Gatwick Airport Northern Runway Project

Draft Development Consent Order – Schedule of Changes

VERSION: 2.0

DATE: APRIL 2024

Title: **Traffic Regulation Plans Classification of Roads APFP Regulations 5(2)(o) Sheet 1A - Proposed Measures**

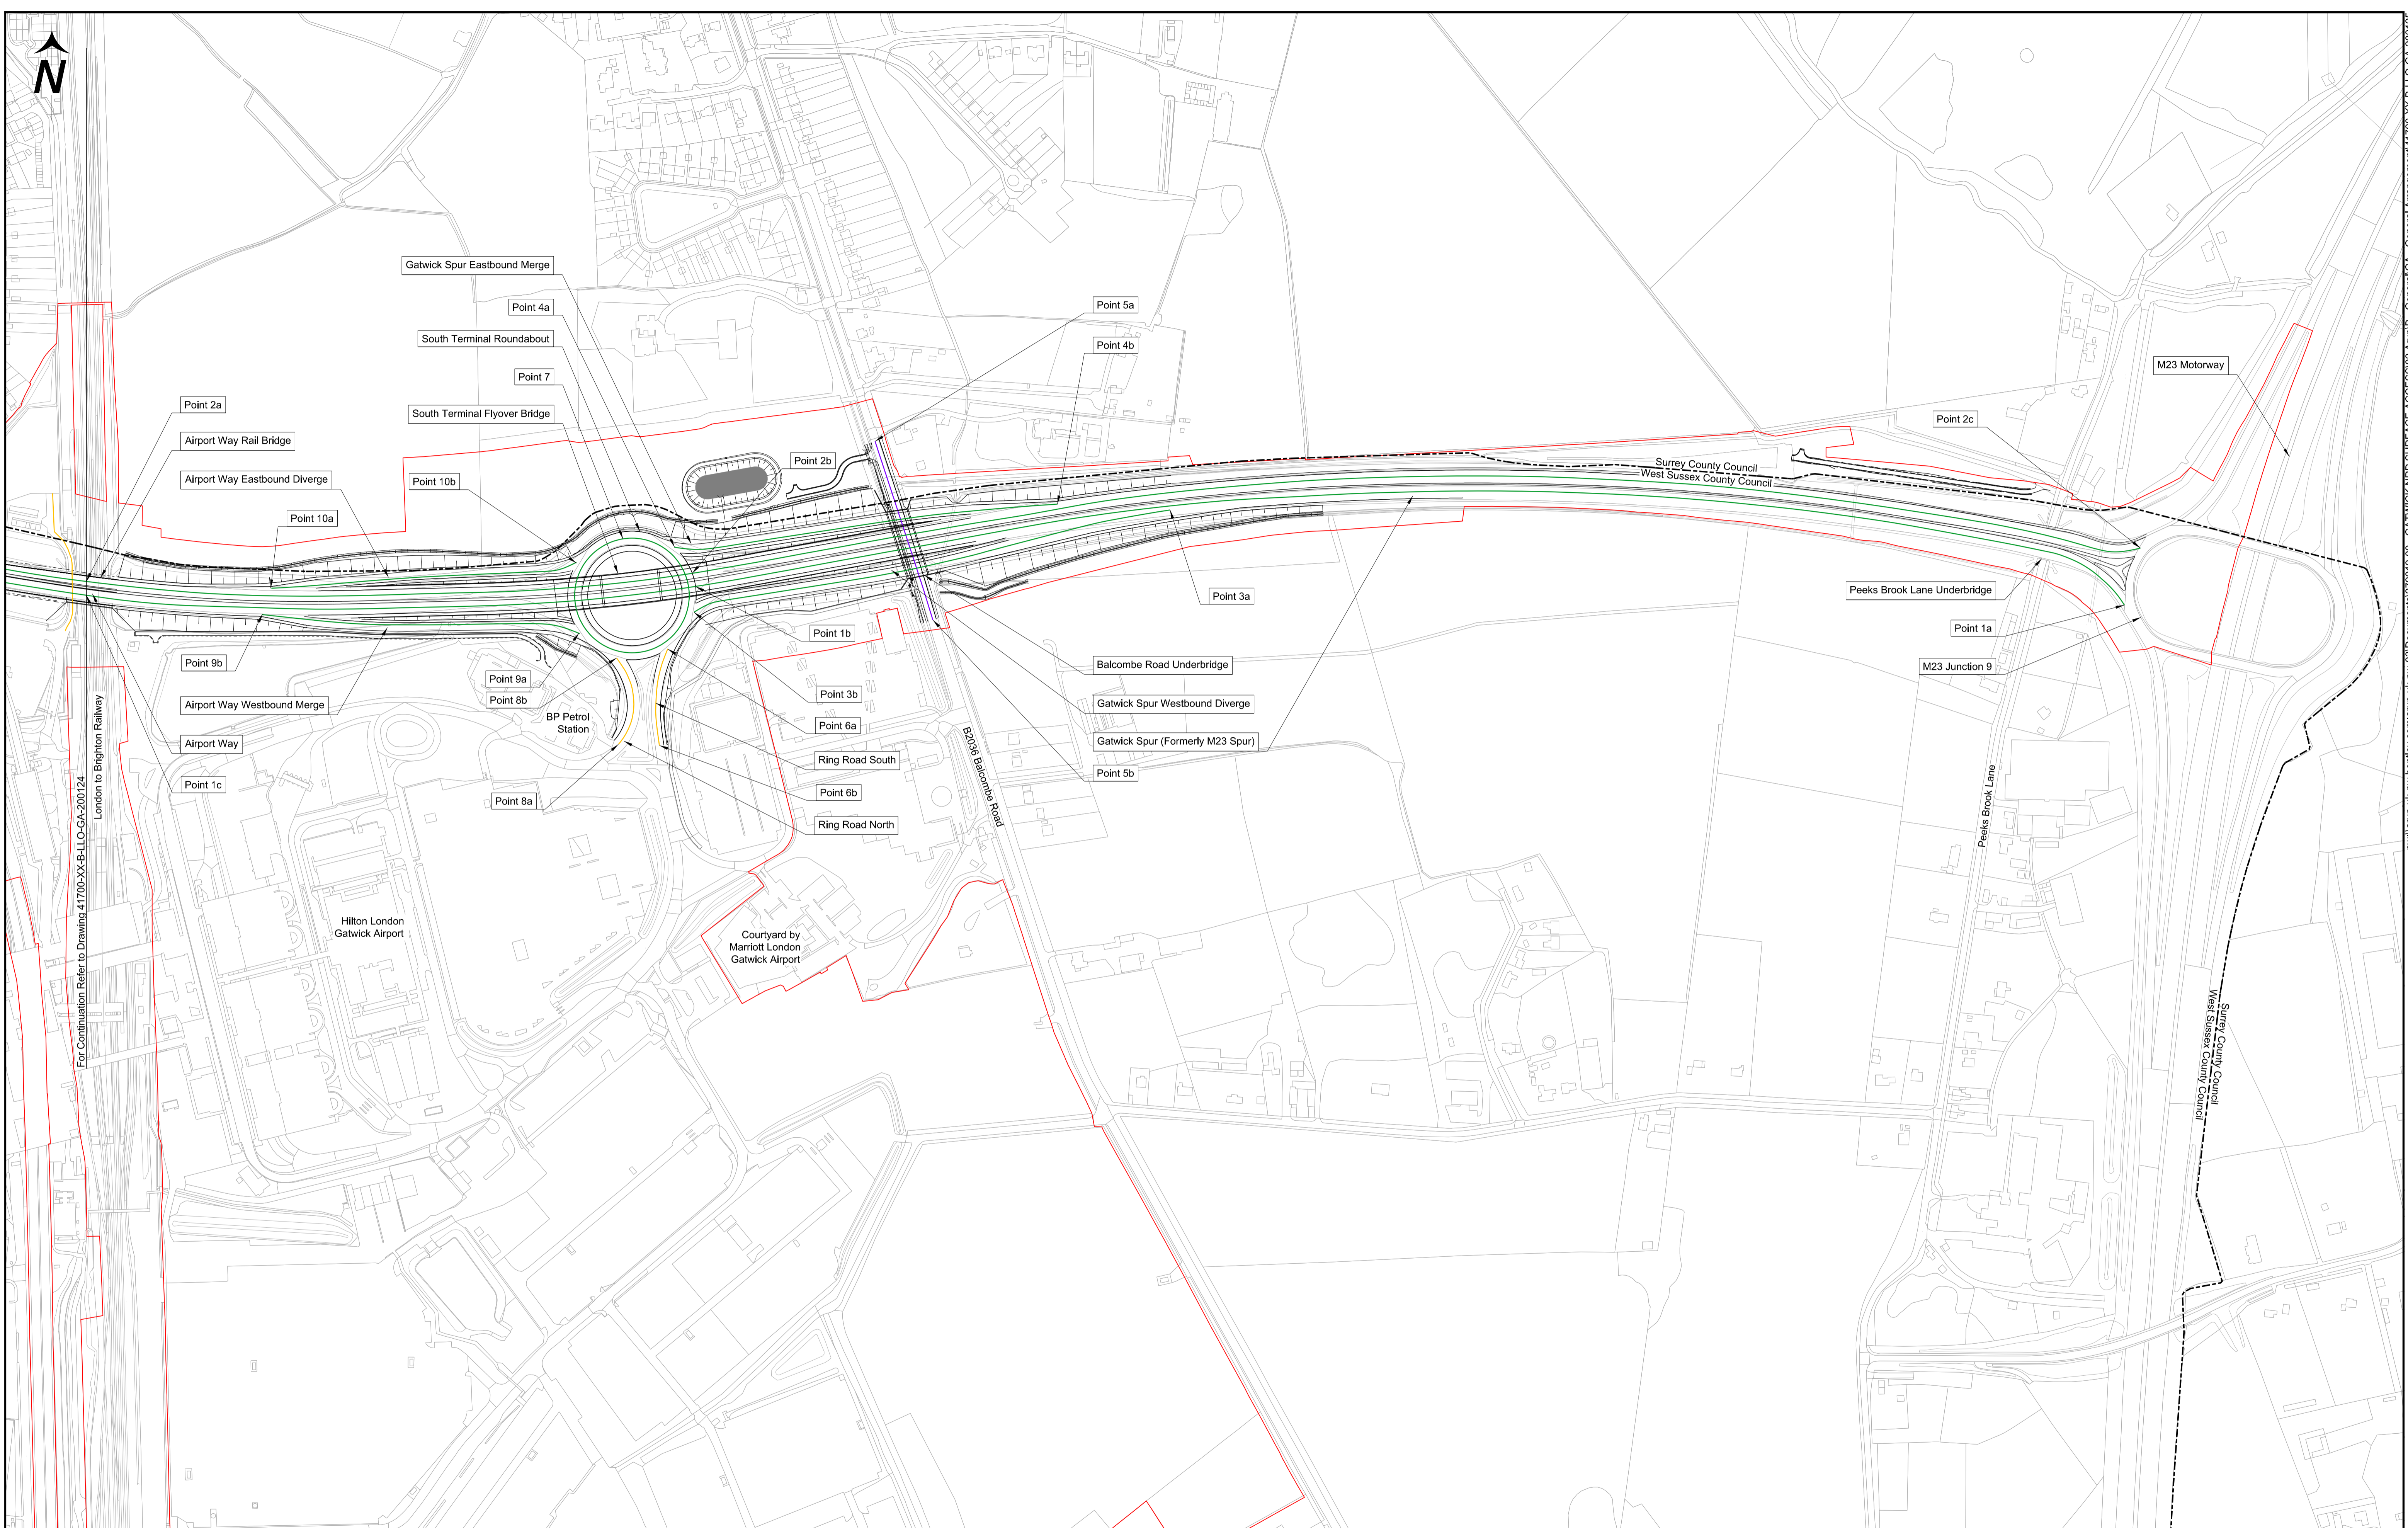
98.	Schedule 3 (stopping up of streets and private means of access & provisions of new streets and private means of access)	<p>Proposed new highway; A23 London Road Northbound Left-in Diverge to North Terminal Roundabout, within the area marked a24 for a distance of approximately 380m 325m as shown on Sheet 1 of the rights of way and access plans, shown by green striped hatching.</p>	<p>Amended to address comments from the Joint West Sussex Authorities.</p>

Title:
Special Category Land Plans - APFP Regulation 5(2)(i) - Sheet 1 of 1

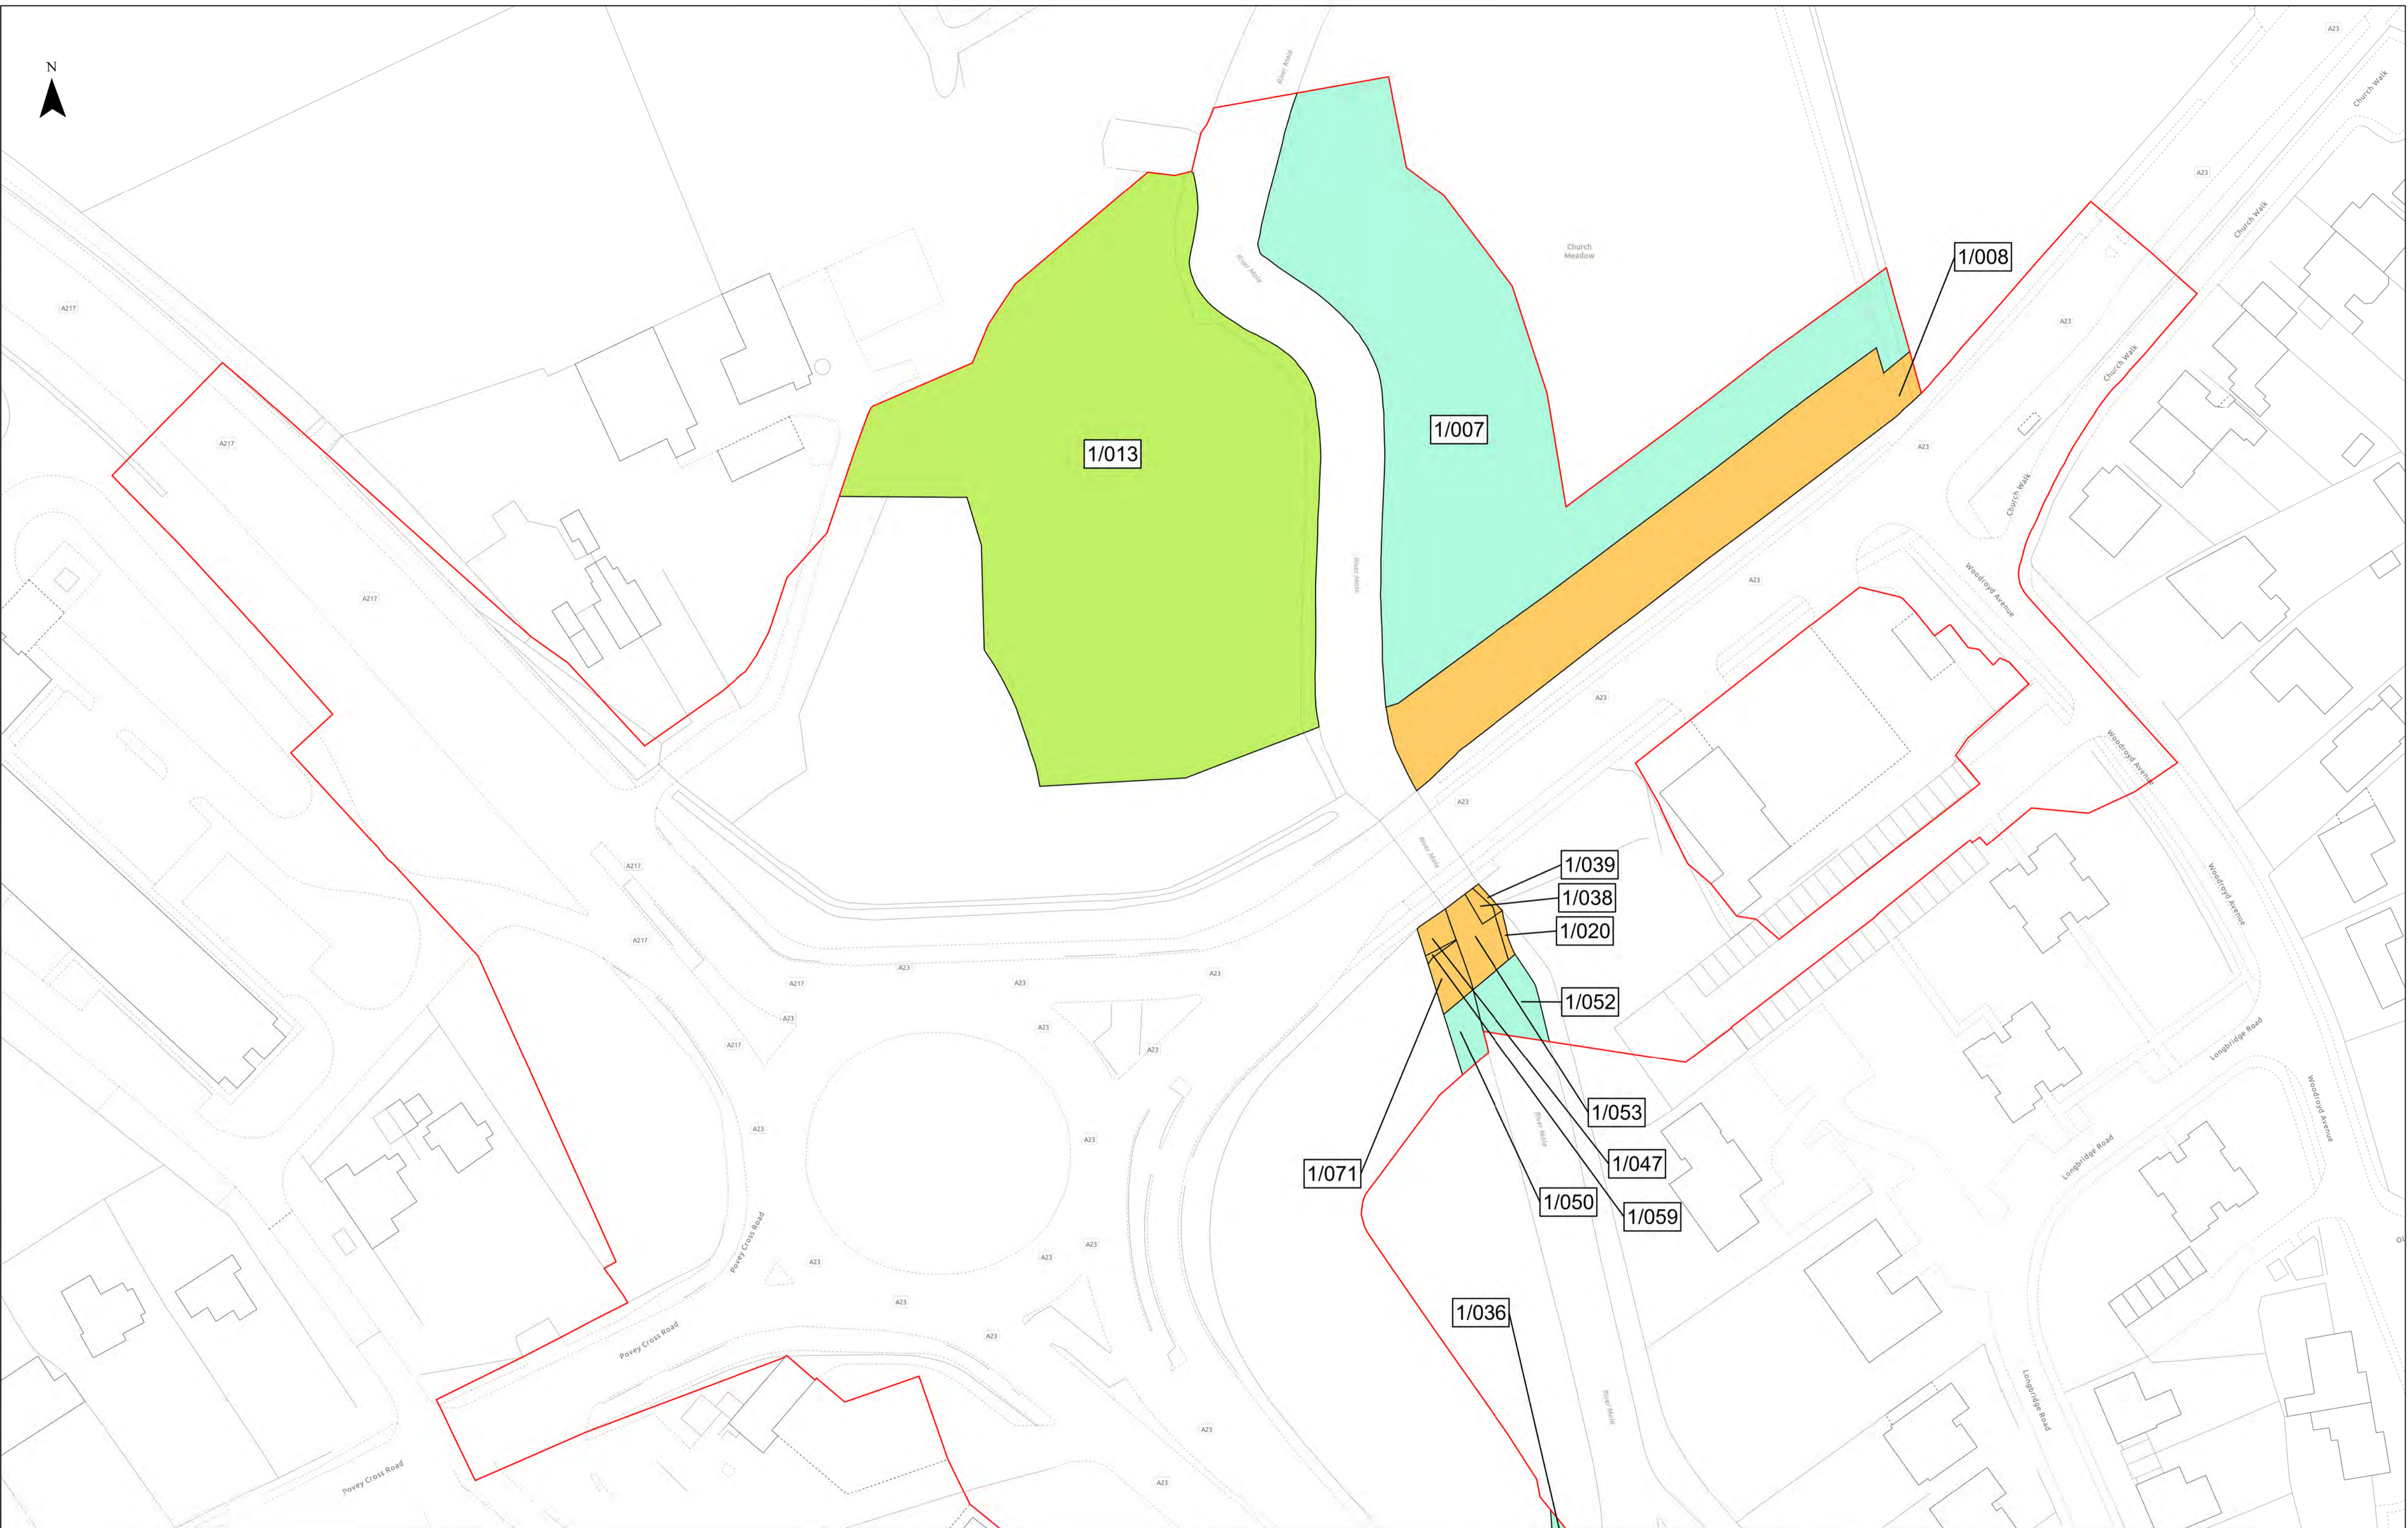
52.	Article 2 (interpretation)	New definition: "special category land" means land forming part of a common, open space or fuel or field garden allotment, as identified shaded orange and blue on the special category land plans;	New definition added for clarity in response to ExQ1 DCO 1.11.
